REFUSAL OF PLANNING PERMISSION

APPLICATION NO. 2018/0630

Proposal Erection of detached single storey granny annexe
At 15 Darton Hall Drive, Darton, Barnsley, S75 5AG

Plans + Elevations Scales 1:50+1:100+1:200+1:2500 May 2018 Dwg JK01

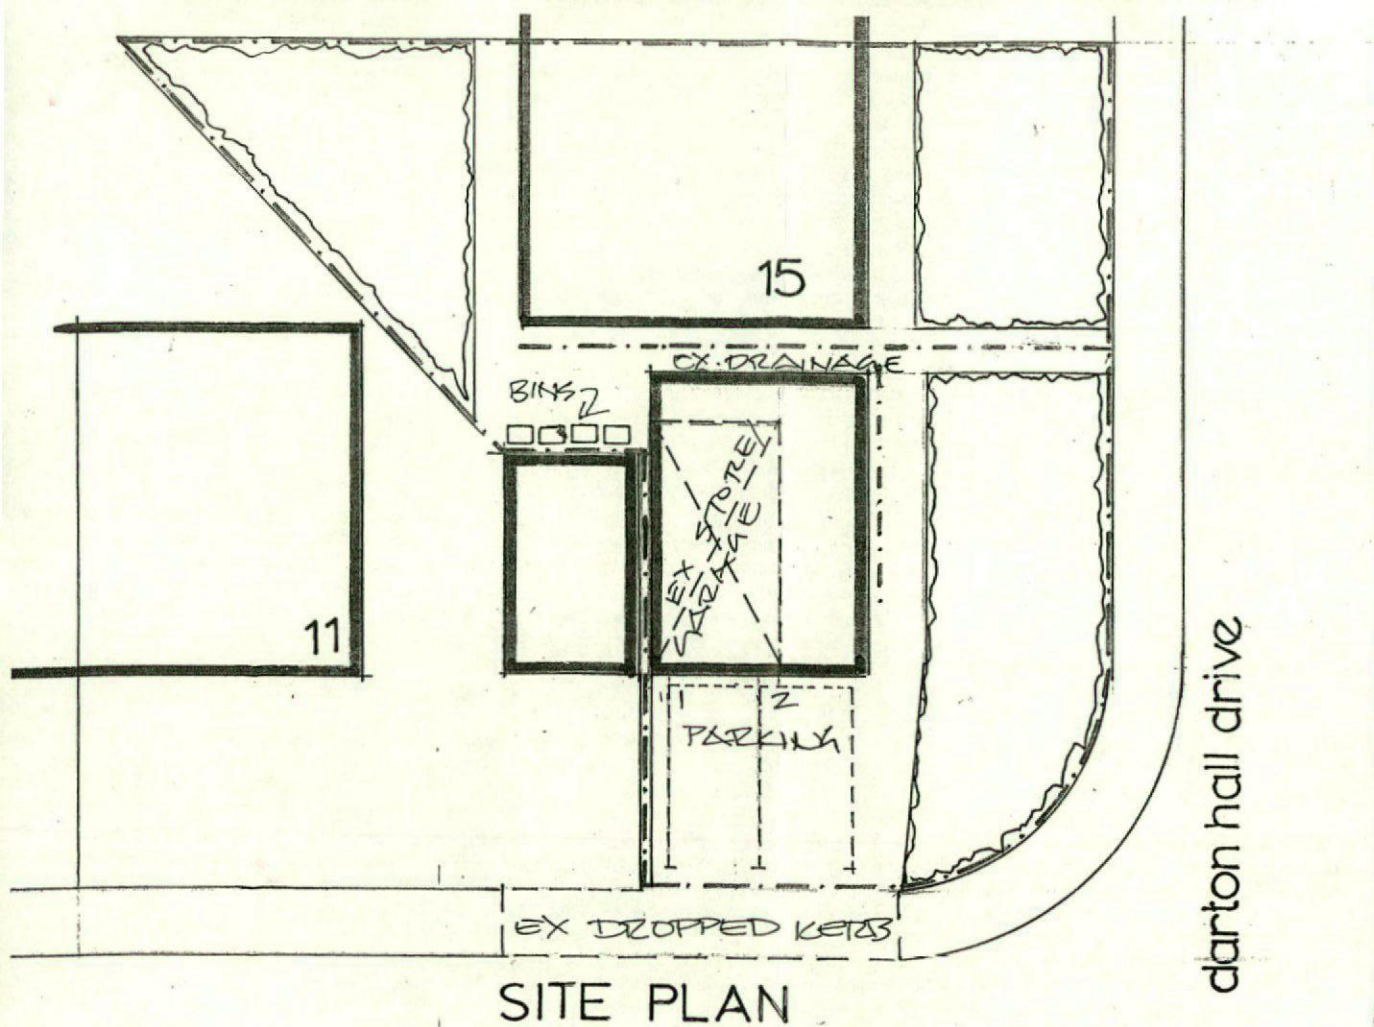
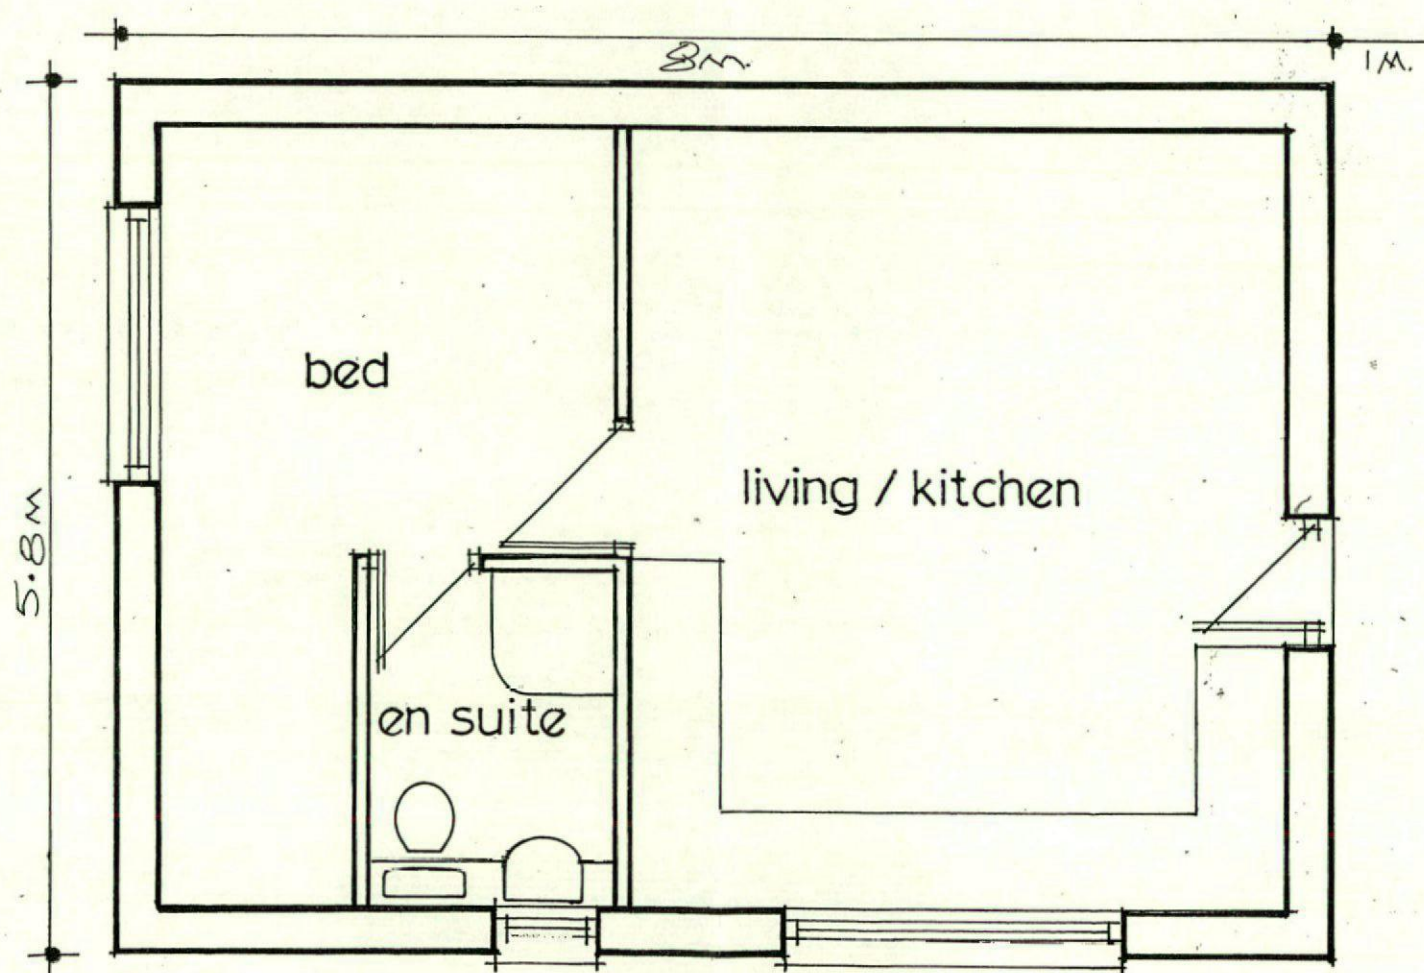
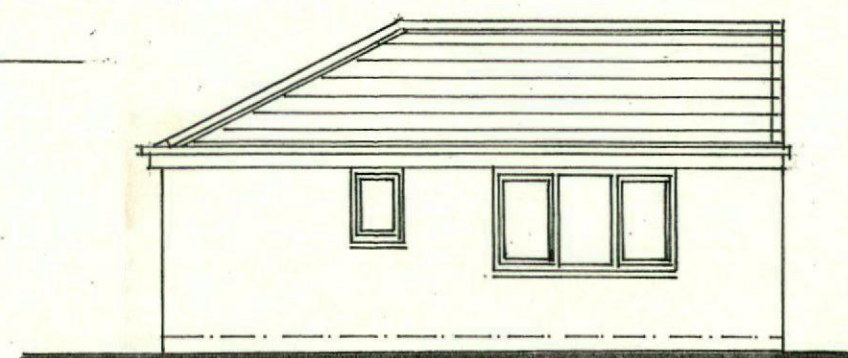
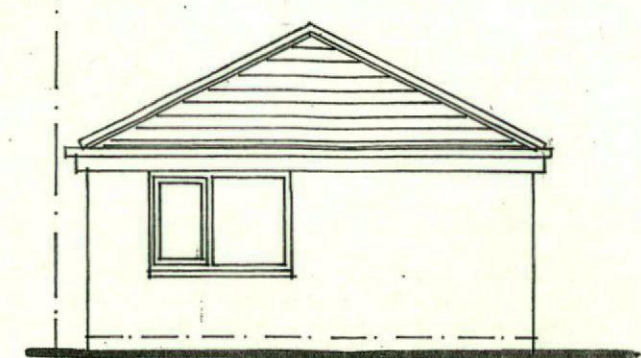
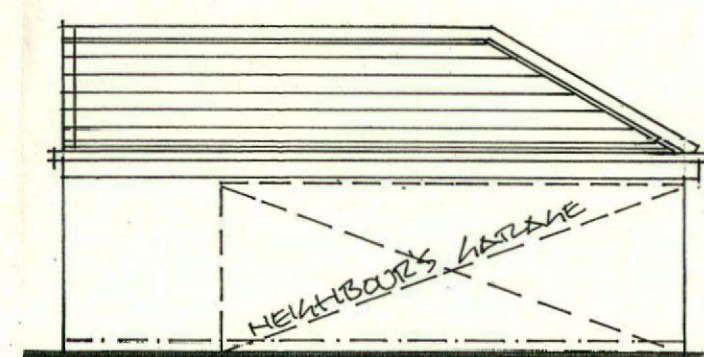
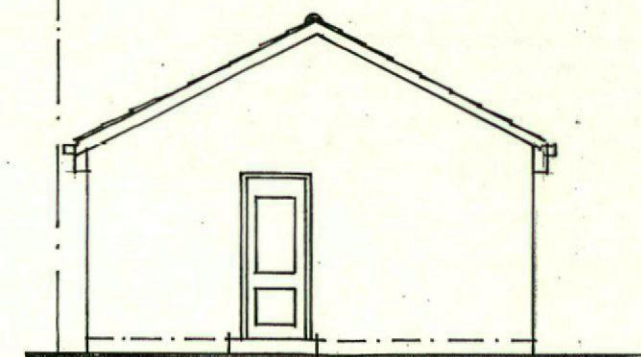
- 1 In the opinion of the Local Planning Authority, the detached outbuilding does not constitute an annex that would be ancillary accommodation to the host dwelling due to its location, disproportionate size, the number and type of rooms to facilitate independent living and the provision of separate access & parking, which is contrary to Core Strategy Policy CSP 29 and Supplementary Planning Document (SPD) - House Extensions.
- 2 In the opinion of the Local Planning Authority the proposed outbuilding would be contrary to the Council's Core Strategy Policy CSP 29 and Supplementary Planning Documents (SPD) 'House Extensions' in that its size would appear as an unduly discordant feature in the street scene to the detriment of visual amenity.
